Fwd: 23 Ocean

Tom Errico <thomas.errico@tylin.com>
To: Helen Donaldson <hcd@portlandmaine.gov>

Thu, Jan 19, 2017 at 9:00 AM

3 SIDEWALK RAMP DETECTABLE WARNING TILE AND APEX RAMP
NOT TO SCALE

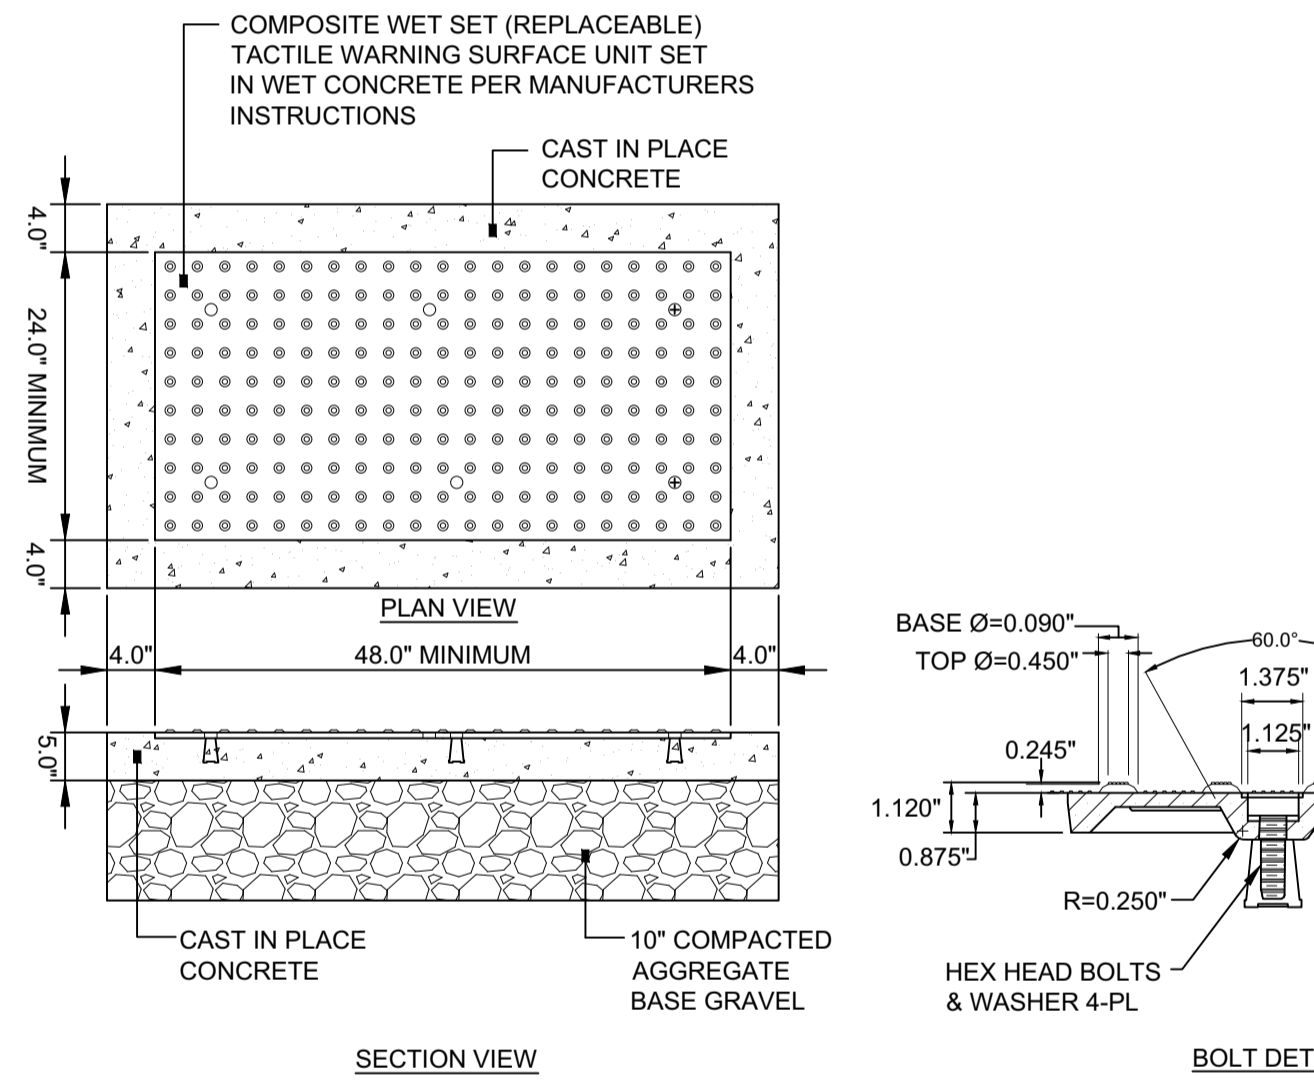
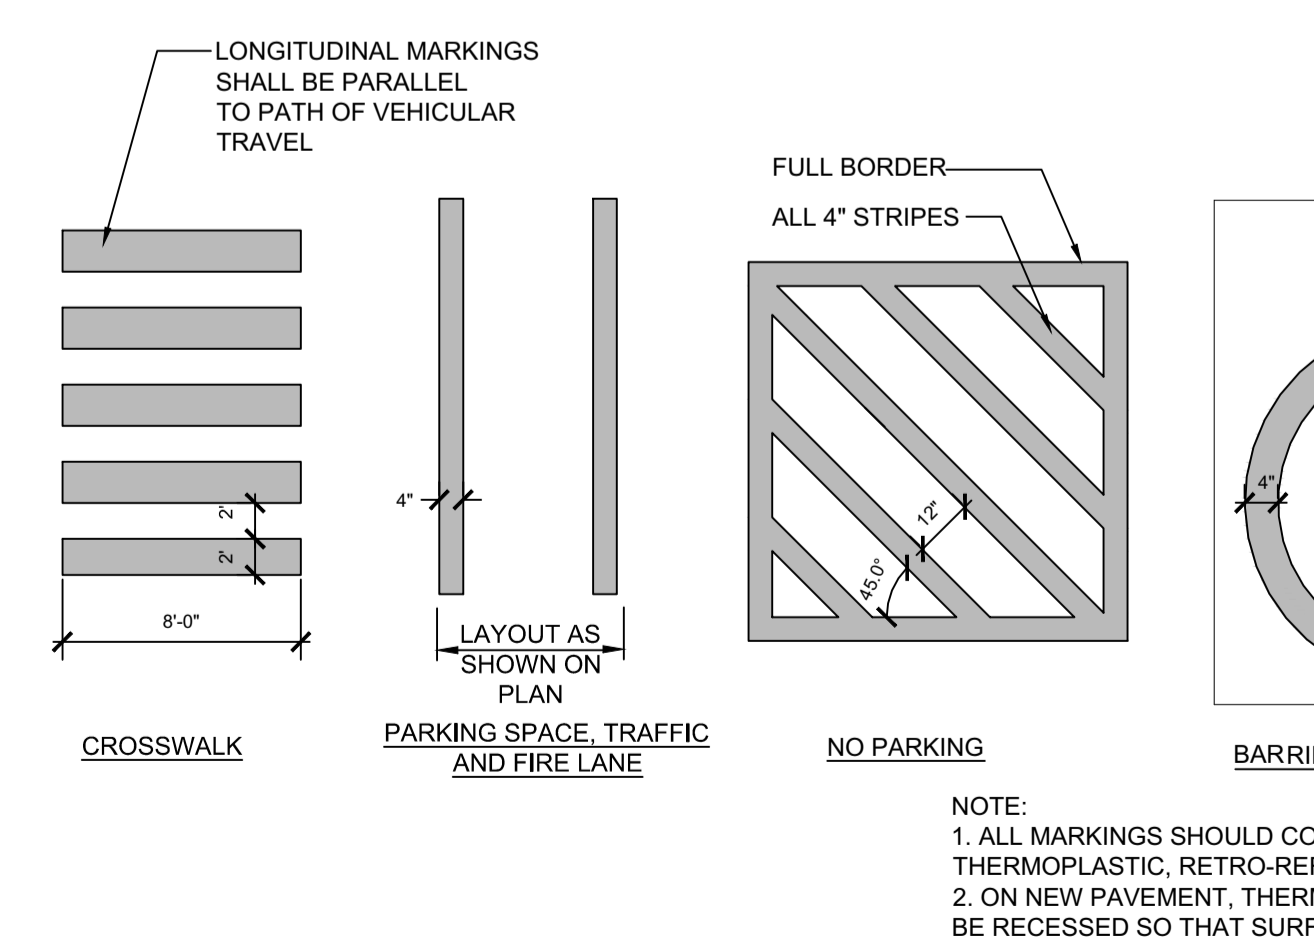
Hersey Ramp – Ransom should review the following and confirm that the panel design meets this requirement (it's easier for them to measure dimensions). Otherwise I find the design to be acceptable.

R305.2.1 Perpendicular Curb Ramps. On perpendicular curb ramps, detectable warning surfaces shall be placed as follows:

1. Where the ends of the bottom grade break are in front of the back of curb, detectable warning surfaces shall be placed at the back of curb.
2. Where the ends of the bottom grade break are behind the back of curb and the distance from either end of the bottom grade brake to the back of curb is 1.5 m (5.0 ft) or less, detectable warning surfaces shall be placed on the ramp run within one dome spacing of the bottom grade break.
3. Where the ends of the bottom grade break are behind the back of curb and the distance from either end of the bottom grade brake to the back of curb is more than 1.5 m (5.0 ft), detectable warning surfaces shall be placed on the lower landing at the back of curb.
